Our Case Number: ABP-314724-22

Re: Railway (Metrolink - Estuary to Charlemont via Dublin Airport) Order [2022]
Metrolink. Estuary through Swords, Dublin Airport, Ballymun, Glasnevin and City Centre to
Charlemont, Co. Dublin

AZ4 (i) Charlemont Station & Turnback - Dartmouth Road

Further to the findings and updates at the Metro Oral Hearing January/February 2024 on plans for the proposed Metro Charlemont Terminus on Grand Canal/Dartmouth Road, I wish to make the following Observations and comments for consideration in Planning decision making.

Client	TII NTA	Project	METROLINK	Drawing Title	METROLINK - STRUCTURES CHARLEMONT STATION PROPOSED STREET LEVEL DESIGN	Drawing Status	S0
Consultant	JACOBS IDOM	Drawing N°	ML1-JAI-SRD-ROUT_XX-DR-Z-02090	Plan Drawing N°	ML-ST 307 O-A1		
		Scales Original Size A1	1:250			Sheet	1 of 6

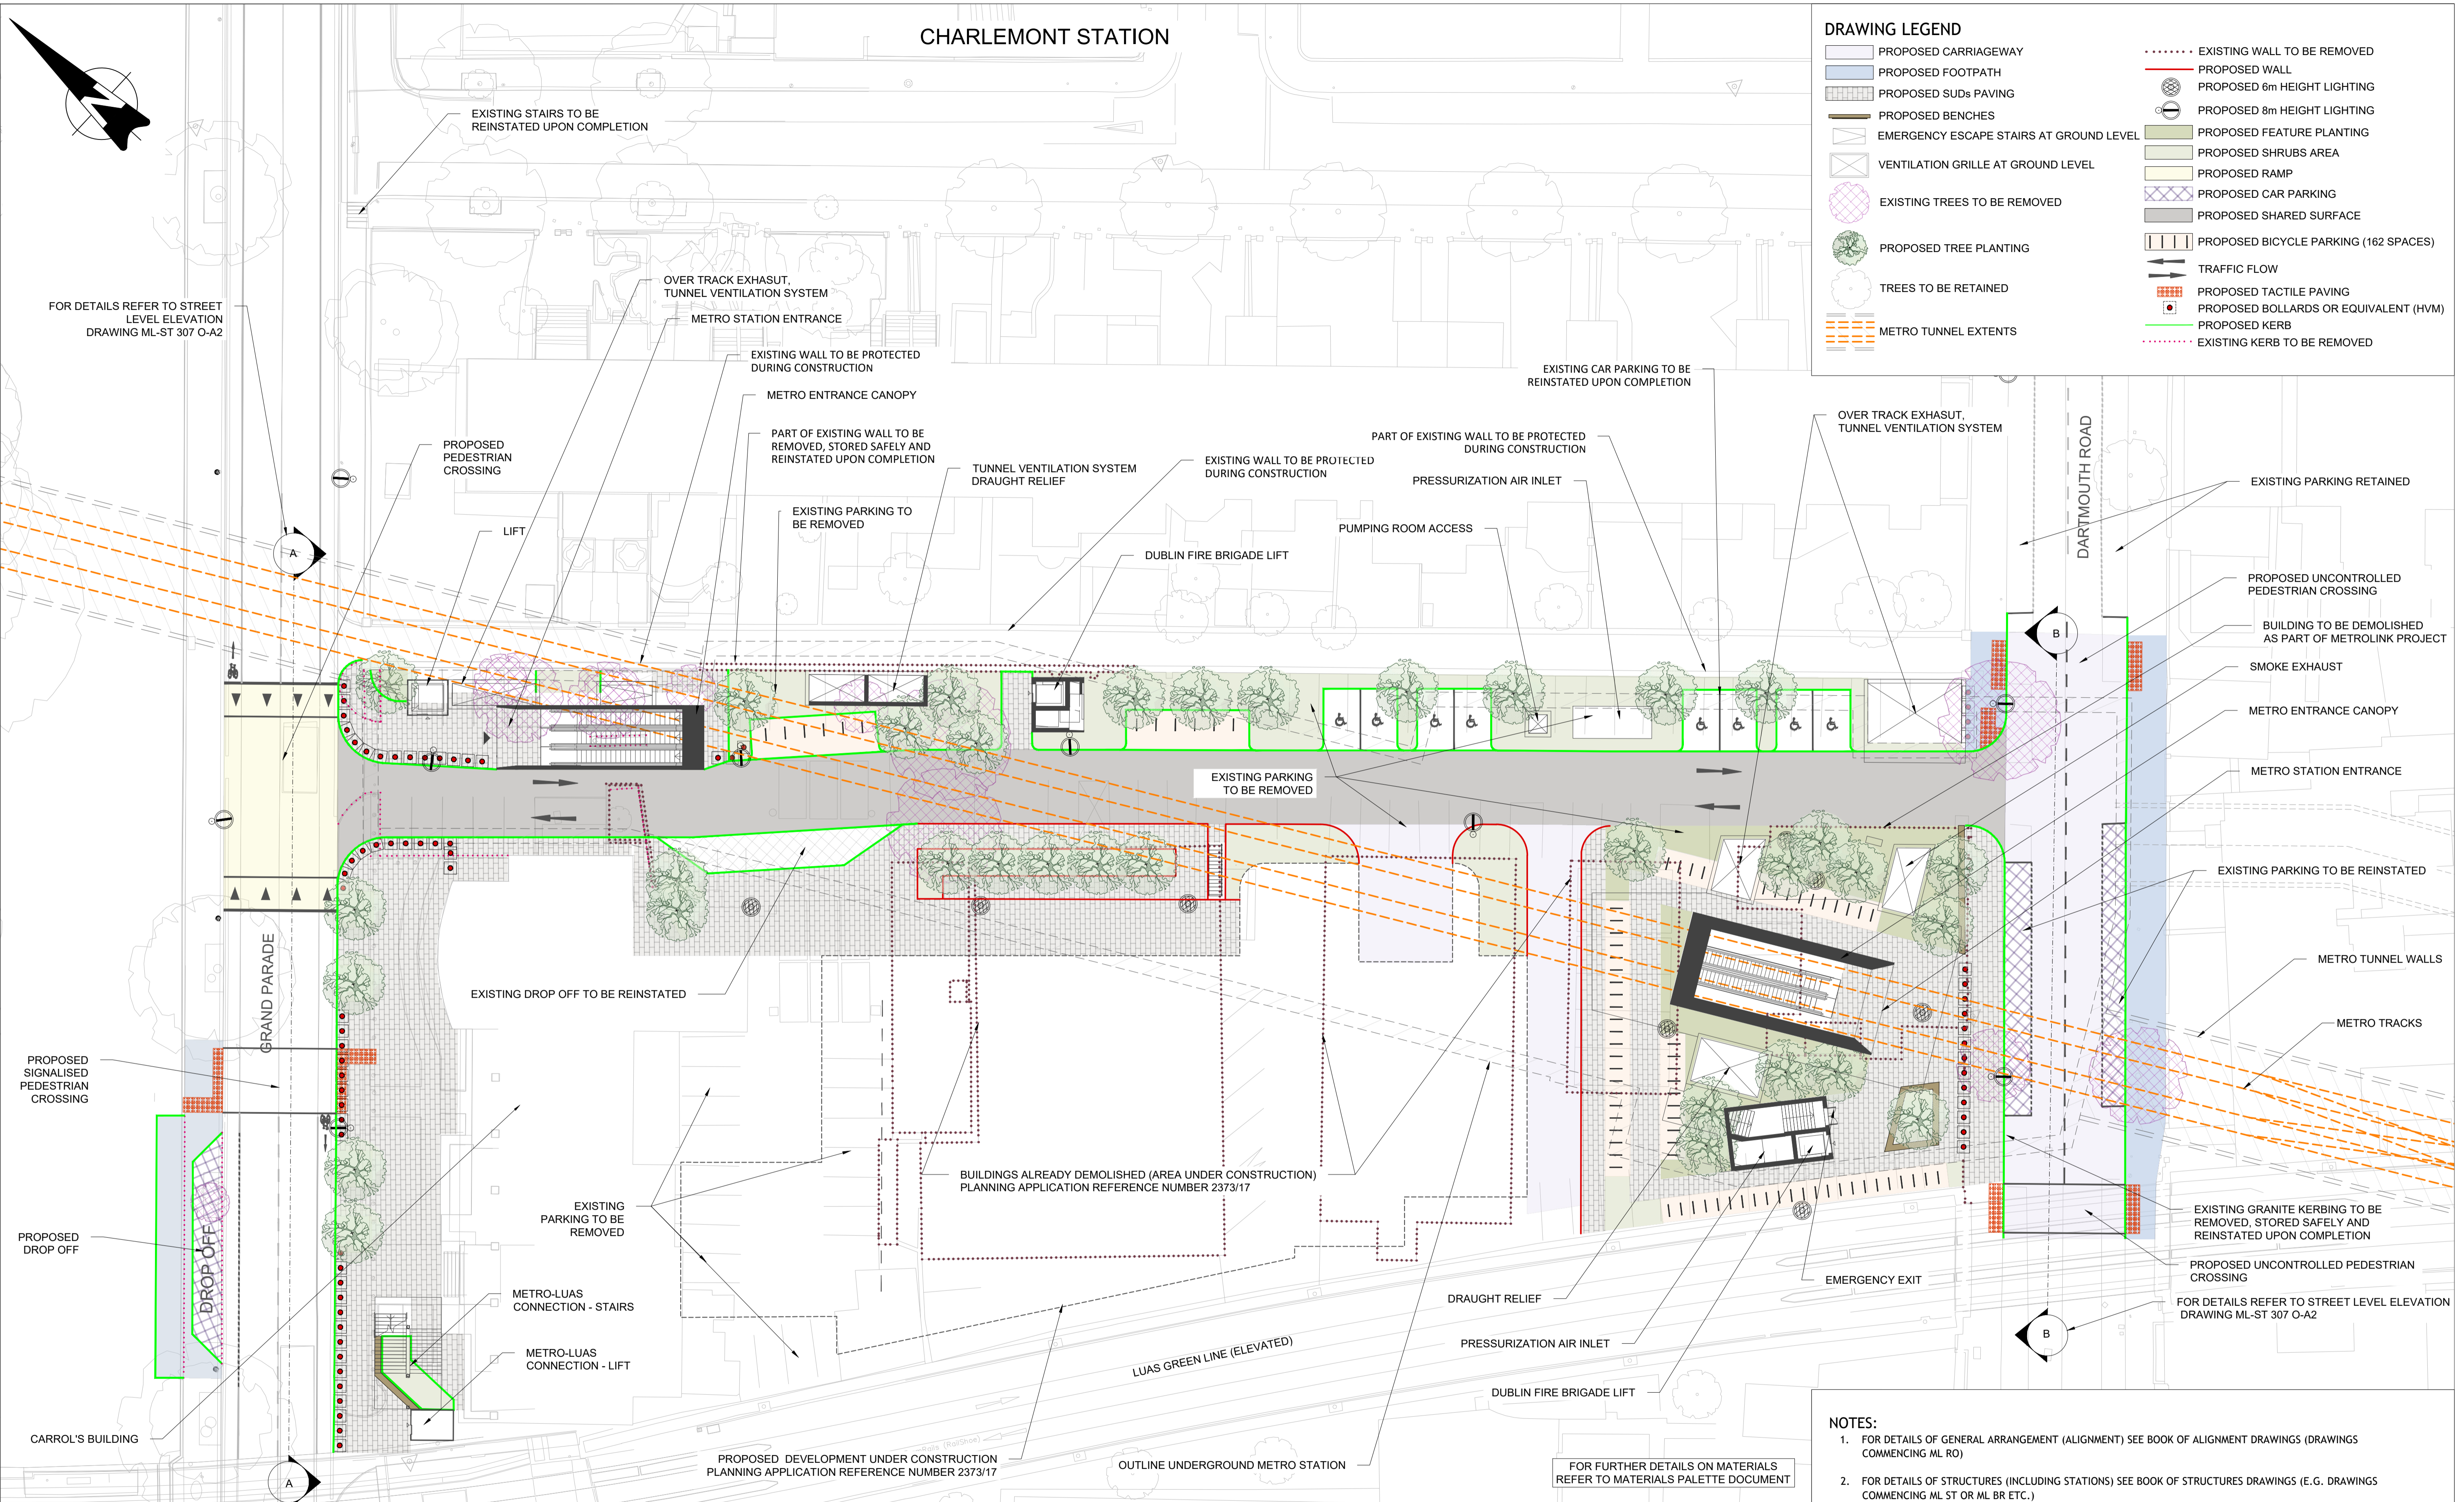
If the road section from Dartmouth Square to the lanes of Dartmouth Place and Dartmouth Tce. is cut off from regular traffic during development and construction period, we loose access to our off street parking for up to 30 months, possibly longer, which is a considerable inconvenience. There is no indication of nearby parking allocation of those of us in the section of road.

Hoarding impacts on property

The front of the house will be 'boxed in' with Luas embankment on the right, and proposed 4 m hoarding directly in front of the properties 32-34 Dartmouth Road, making the ground floor very dark. Reduced light, creating a claustrophobic feeling of being boxed in.

There are also security issues, private gateways should be protected. Already there is an issue of railing base stones disturbed from a large Lime tree within the road pavement. A deep dig in this area may also have significant impact on railing settings which are also a Listed part of the property frontage.

Littering issues will increase with all pedestrian traffic reduced to one side of the road, outside our property.

- Dartmouth Road closed to traffic for 2.5 to up to 5 years to facilitate Utility diversions and Main station box works
- Works area will extend up to south footway, though access to the properties will be maintained at all time.
- Environmental impacts will be mitigated, residents most affected by the works will be given the opportunity to relocate during critical work phases.
